CITY OF ALBUQUERQUE

October 20, 2021

**Re: KABQ CARGO FACILITY
2200 Sunport Blvd SE
Traffic Circulation Layout
Engineer's Stamp 10-18-2021 (P15-D004)**

All comments are in references to proposed Site Plan (sheet C-200)

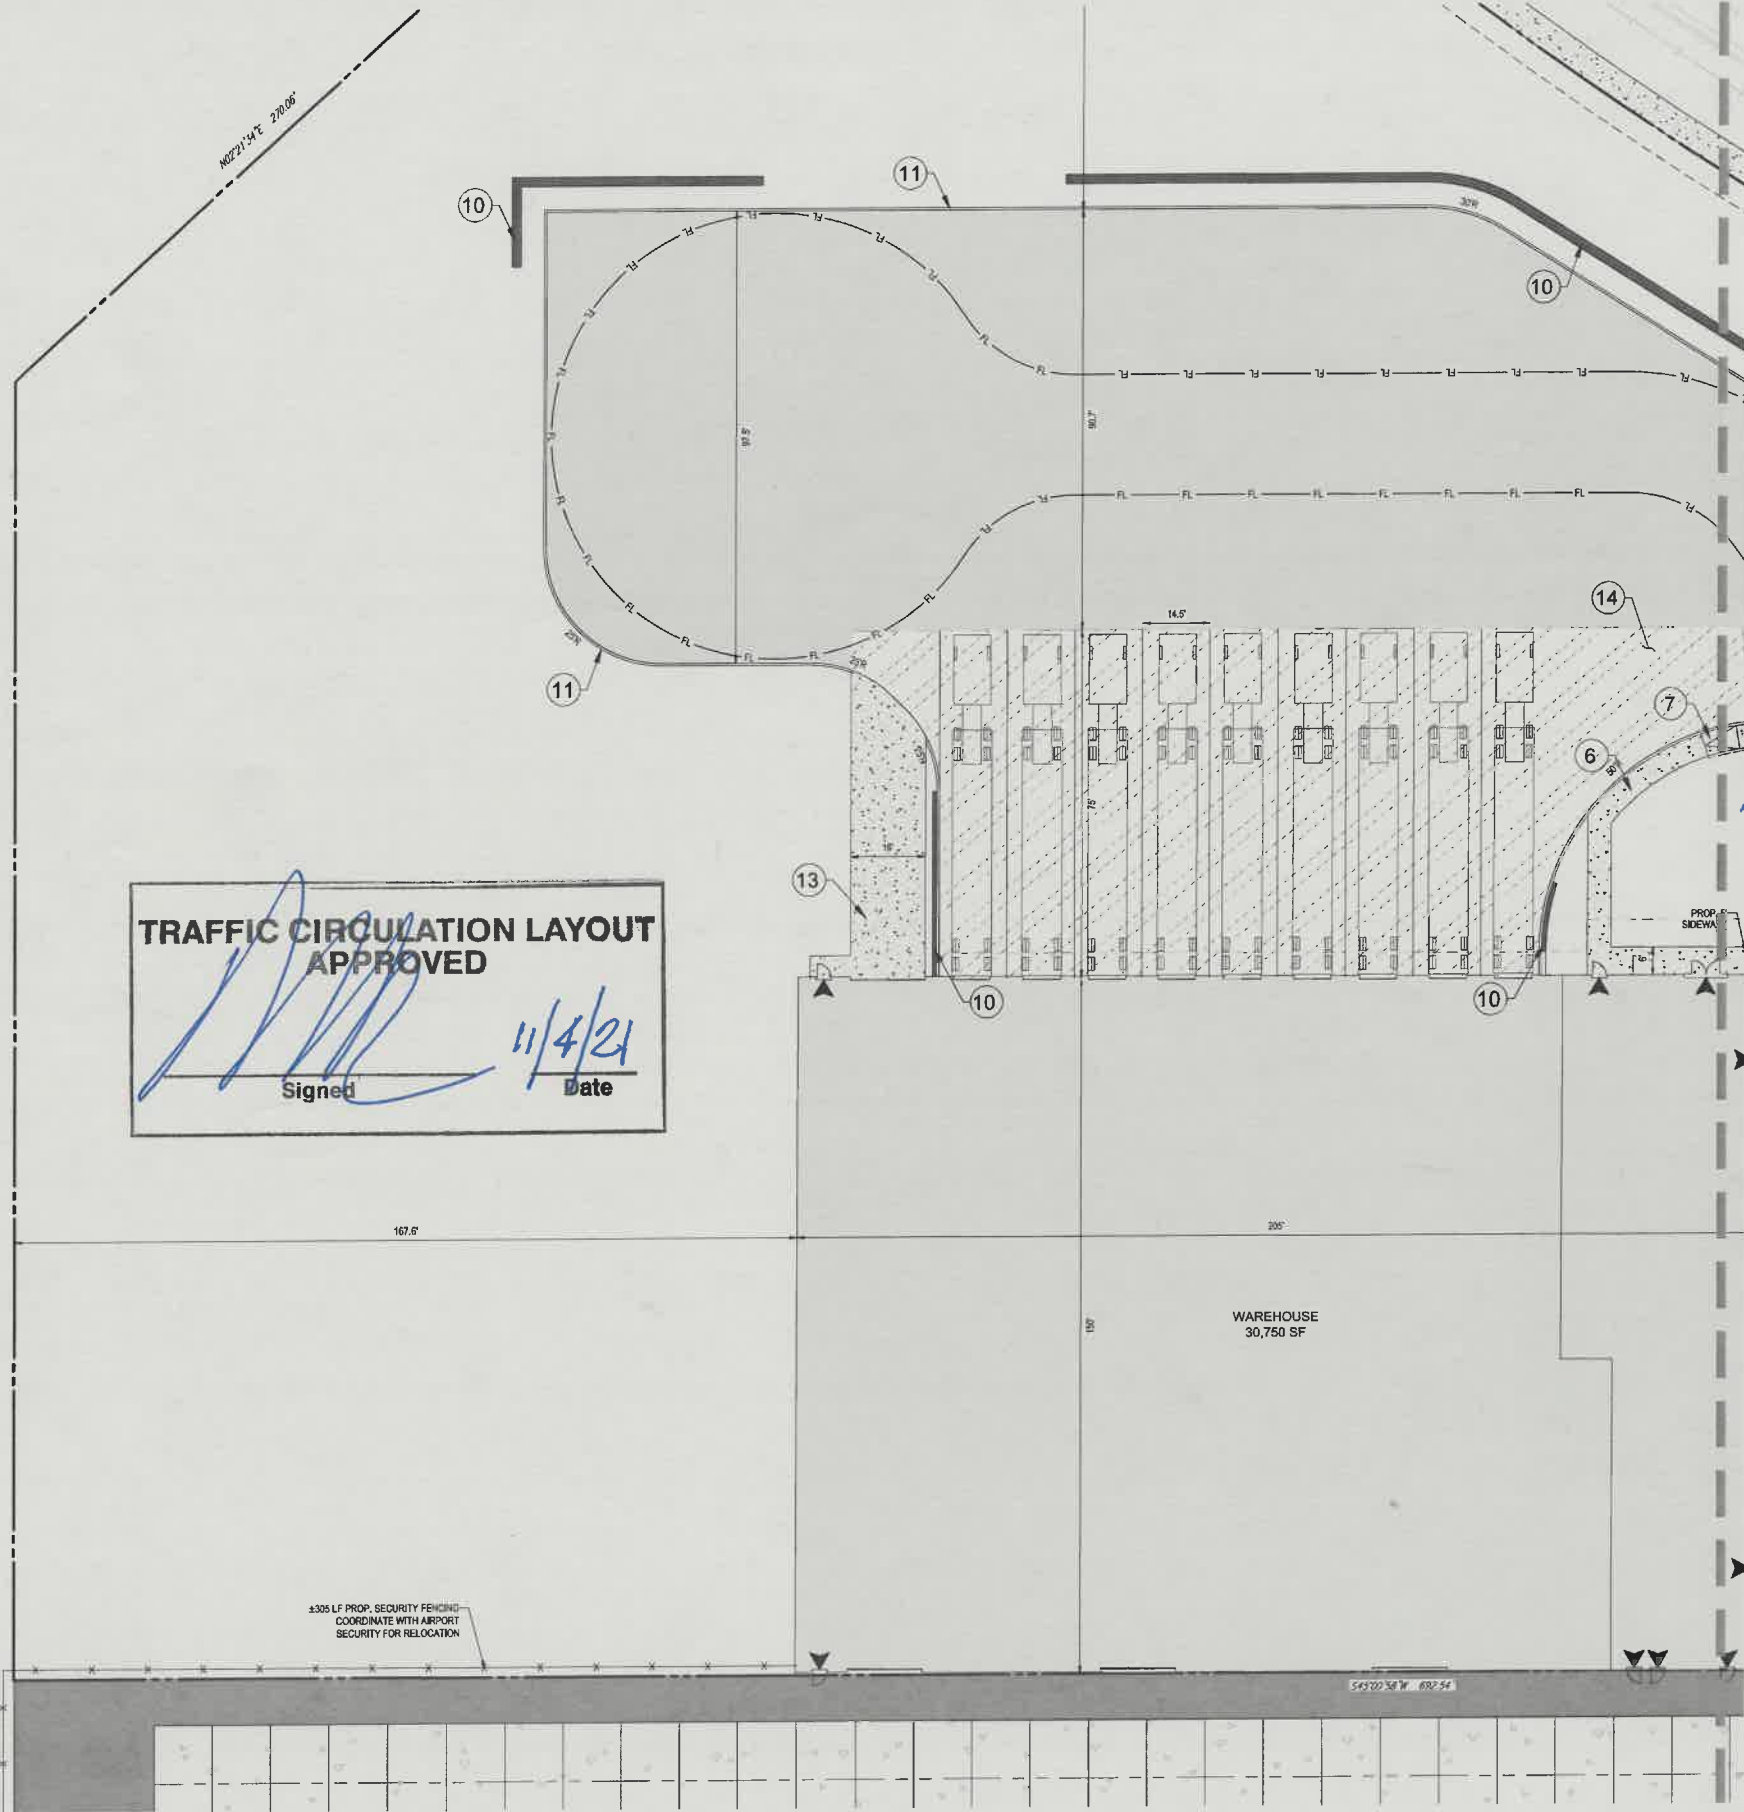
1. Listed are the number of parking spaces required by the IDO as well as the proposed number of parking spaces including bicycle and motorcycle parking.
Coordinate/discuss with Zoning.

2. **Spirit Drive frontage:**
 - What is the status of driveway connection onto Spirit Drive? Existing? Proposed?
 - Sidewalk status around the parameter off proposed development? Sidewalk is required on Spirit Drive frontage as well as ADA ramp.

3. Driveway design will be needed off access road onto site. This shall include sidewalk, ramps, curbing, valley gutter. **Provide construction notes to define this driveway entrance design.**

4. Provide a separate exhibit demonstrating turning movements on/off Spirit, access road and driveway entrance.
5. **Details and Construction notes:**
 - will be required on this Site Plan for all proposed Parking lot infrastructure, pavements markings, striping etc...

- Signage and sign face details
6. A scale of 1"=20' is recommended for sites less than 5 acres.
7. Identify the right of way width, street widths on Spirit Drive and Access road.

10. The ADA accessible parking sign must have the required language per 66-7-352.4C NMSA 1978 **"Violators Are Subject to a Fine and/or Towing."** Please call out detail and location of signs.

11. The ADA access aisles shall have the words **"NO PARKING"** in capital letters, each of which shall be at least one foot high and at least two inches wide, placed at the rear of the parking space so as to be close to where an adjacent vehicle's rear tire would be placed. (66-1-4.1.B NMSA 1978)

12. ADA curb ramps must be updated to current standards and have truncated domes installed. **Details will need to be provided.**
13. Motorcycle parking spaces shall be designated by its own conspicuously posted upright sign, either free-standing or wall mounted per the zoning code. Label pavement MC.

16. A 1-foot clear zone around the bicycle parking stall shall be provided.
17. Bicycle parking spaces shall be at least 6 feet long and 2 feet wide.
18. Per the IDO, a 6 ft. wide ADA accessible pedestrian pathway is required from the public sidewalk to the building entrances. Please clearly show this pathway and provide details.

19. Per DPM, a 6 ft. wide ADA accessible pedestrian pathway is required from the ADA parking stall access aisles to the building entrances. Please clearly show this pathway and provide details.

20. ADA accessible pedestrian pathway should not be placed behind parking space or adjacent to a vehicular way. Vehicle and pedestrian/wheel chair conflicts should be avoided as much as possible.

21. All sidewalks along streets should be placed at the property line.
22. Curbing should be installed to delineate parking, and pedestrian ways and identify points of access. Please call out detail and location of barrier curb.

23. Parking areas shall have barriers to prevent vehicles from extending over sidewalk,
24. Provide a copy of refuse approval.
25. Fire 1 plan approval will be required.

26. It is not apparent what type of pavement surface is being proposed. A hard driving surface will be required as part of this proposed project for parking area and drive aisles.

27. Please provide a sight distance exhibit
28. Show the clear sight triangle and add the following note to the plan: "Landscaping and signage will not interfere with clear sight requirements. Therefore, signs, walls, trees, and shrubbery between 3 and 8 feet tall (as measured from the gutter pan) will not be acceptable in the clear sight triangle.
